# The Planning Inspectorate

### Application by Anglian Water for an Order Granting Development Consent for the Cambridge Waste Water Treatment Plant Relocation project

#### Procedural Decision

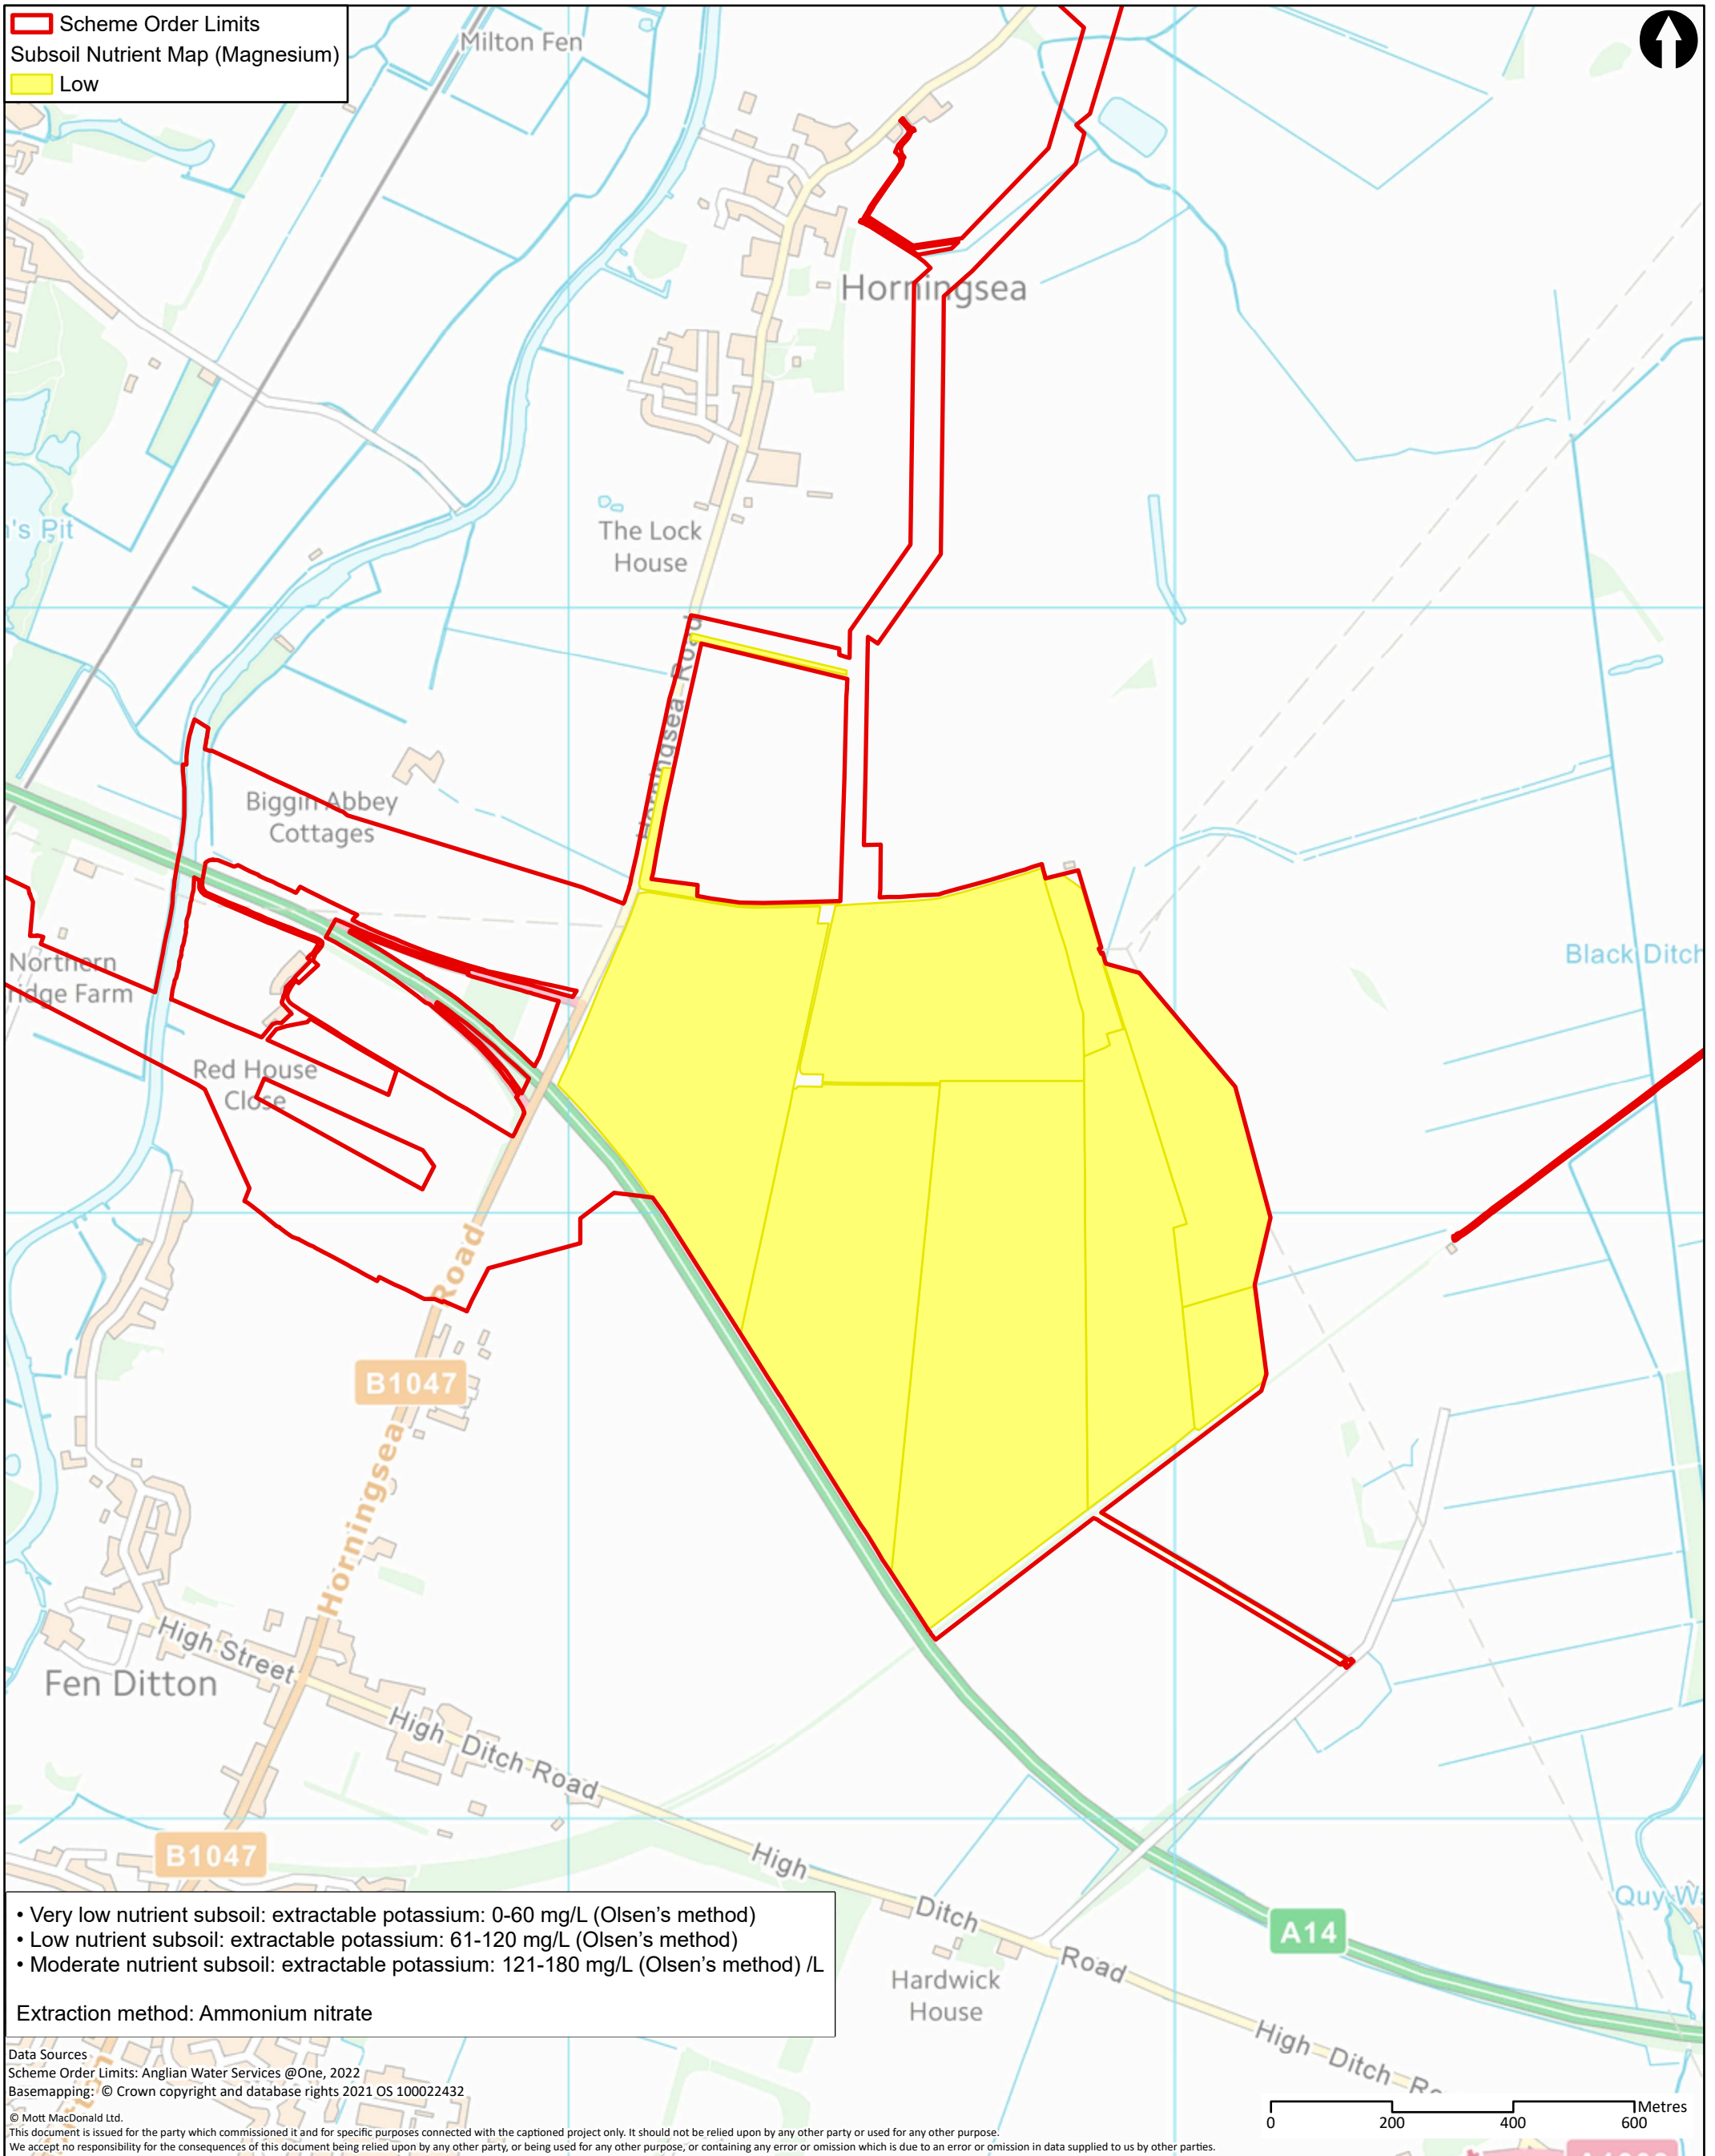
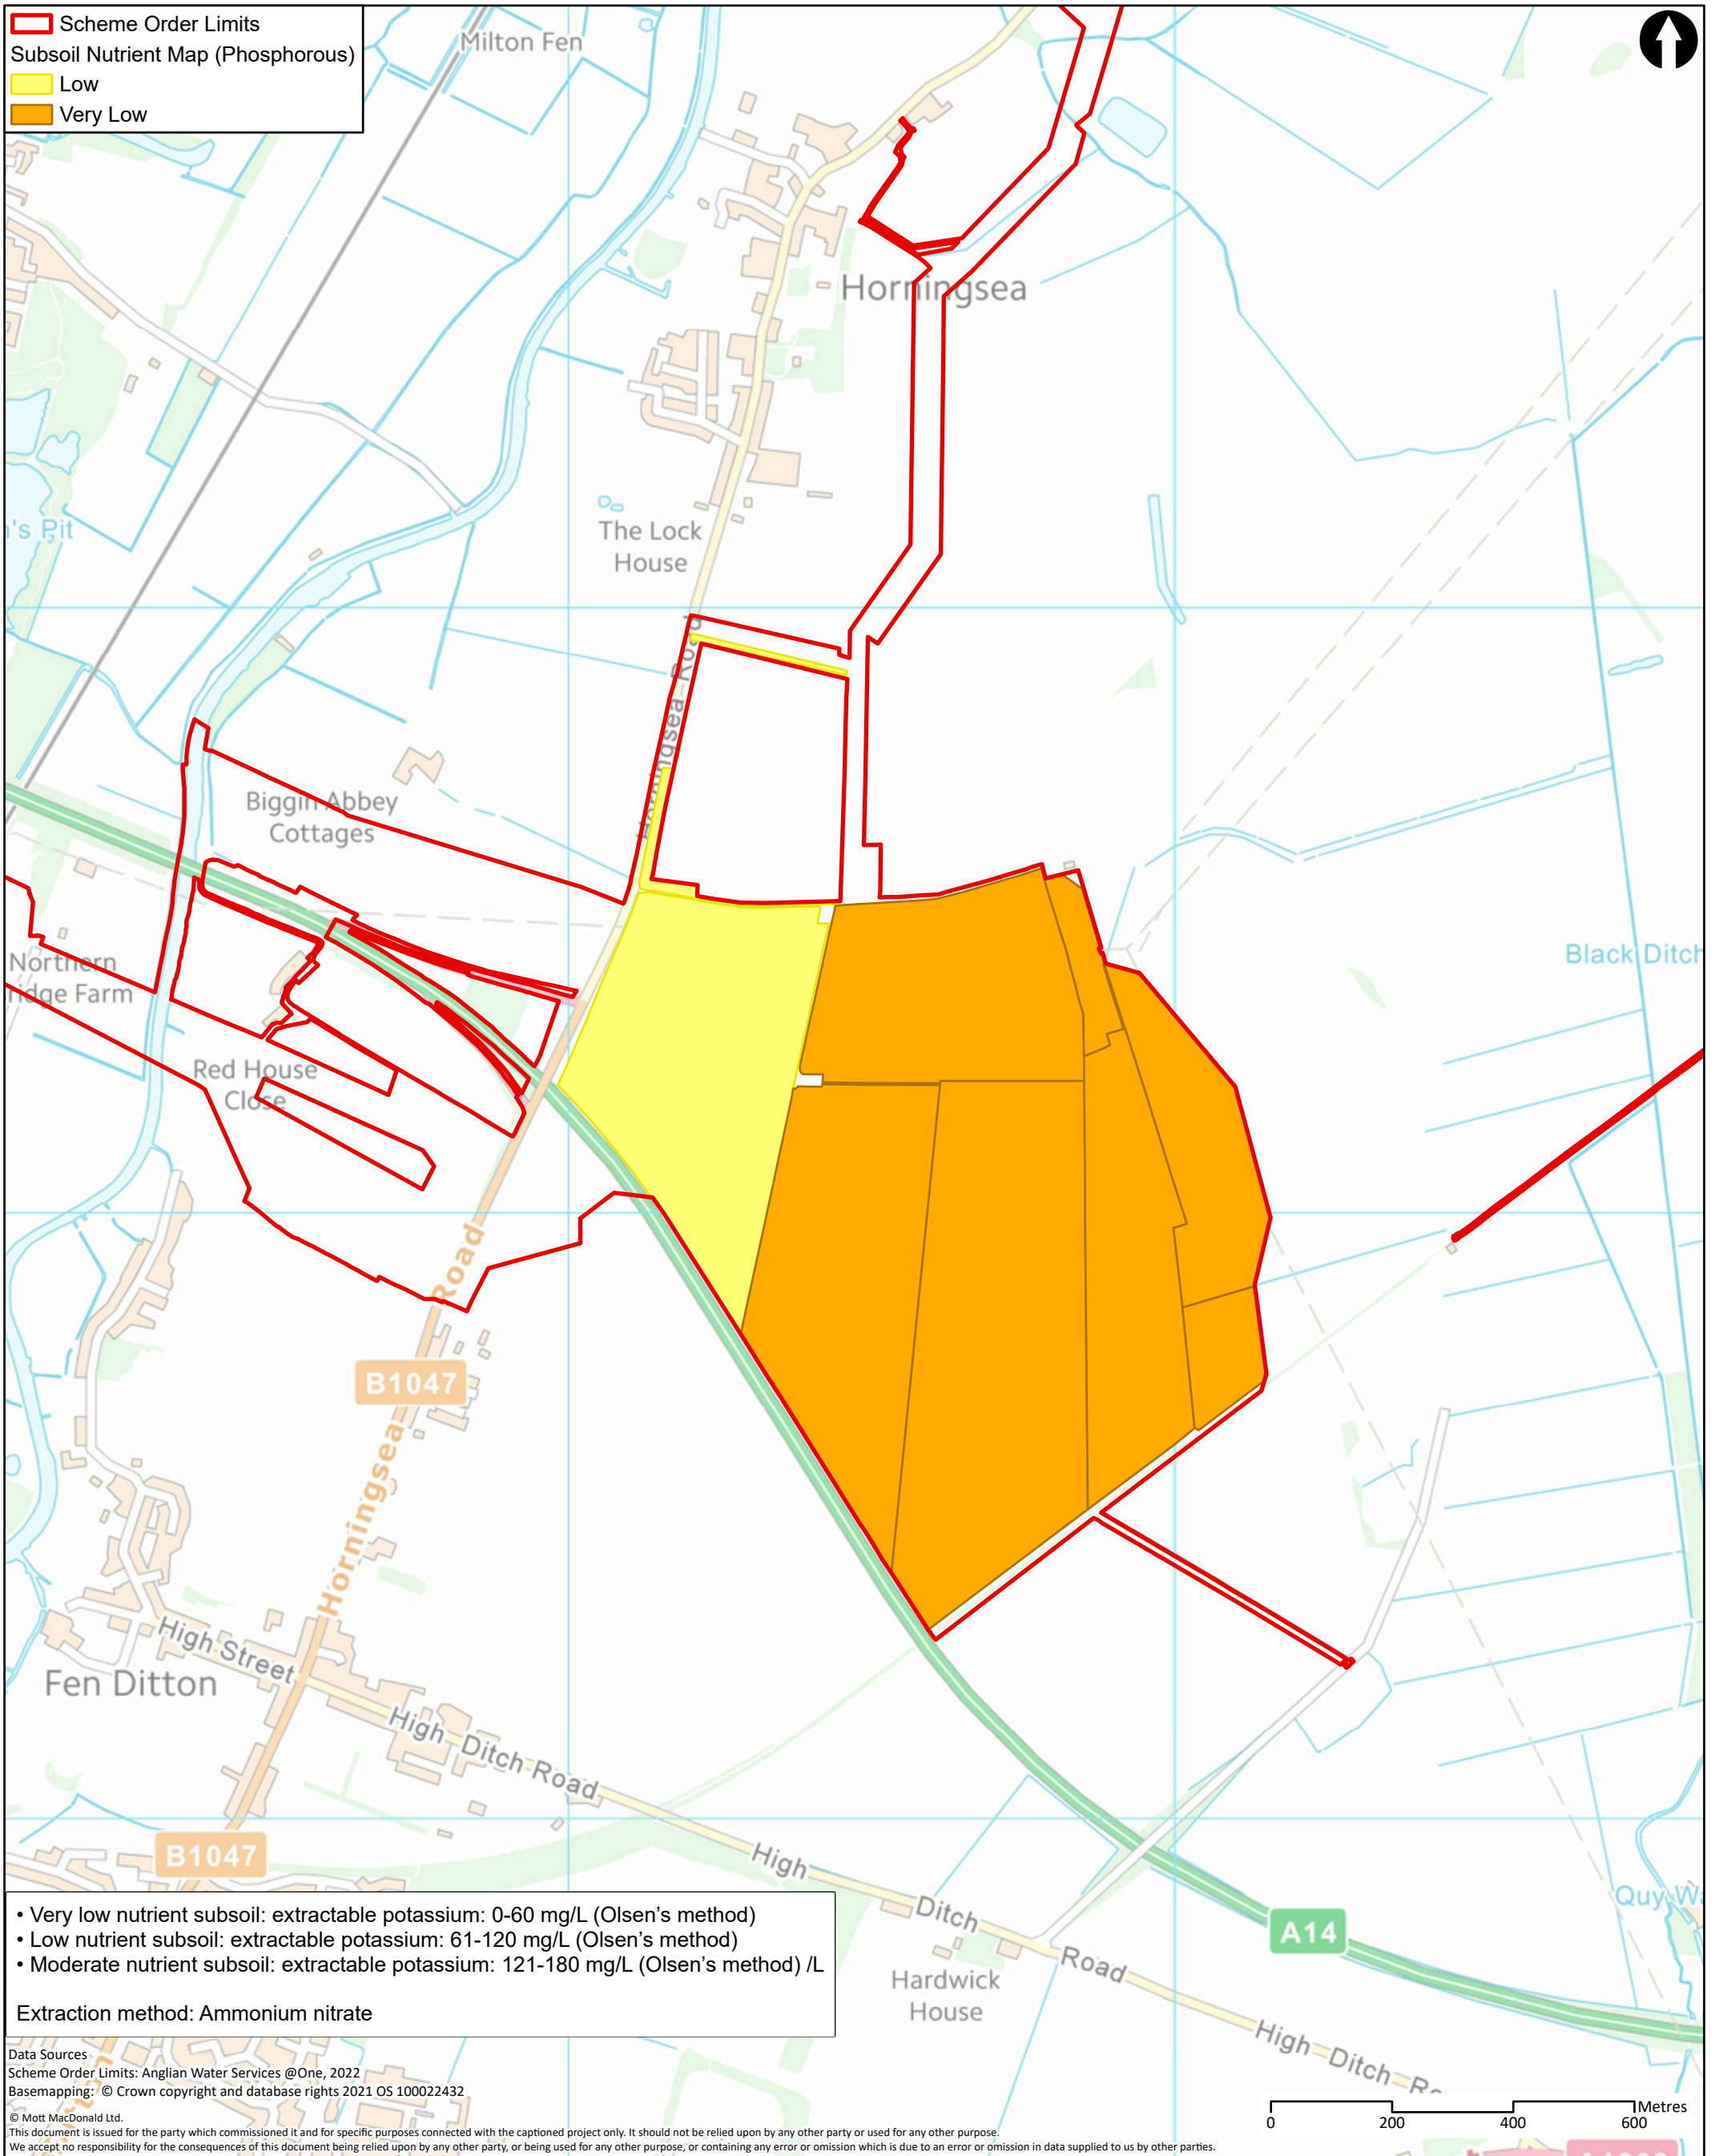
Incorrect information is presented in ES Figures 6.5, 6.6, 6.8 and 6.9, given that potassium ranges are displayed rather than magnesium and phosphorus ranges to which the figures relate. Please address.
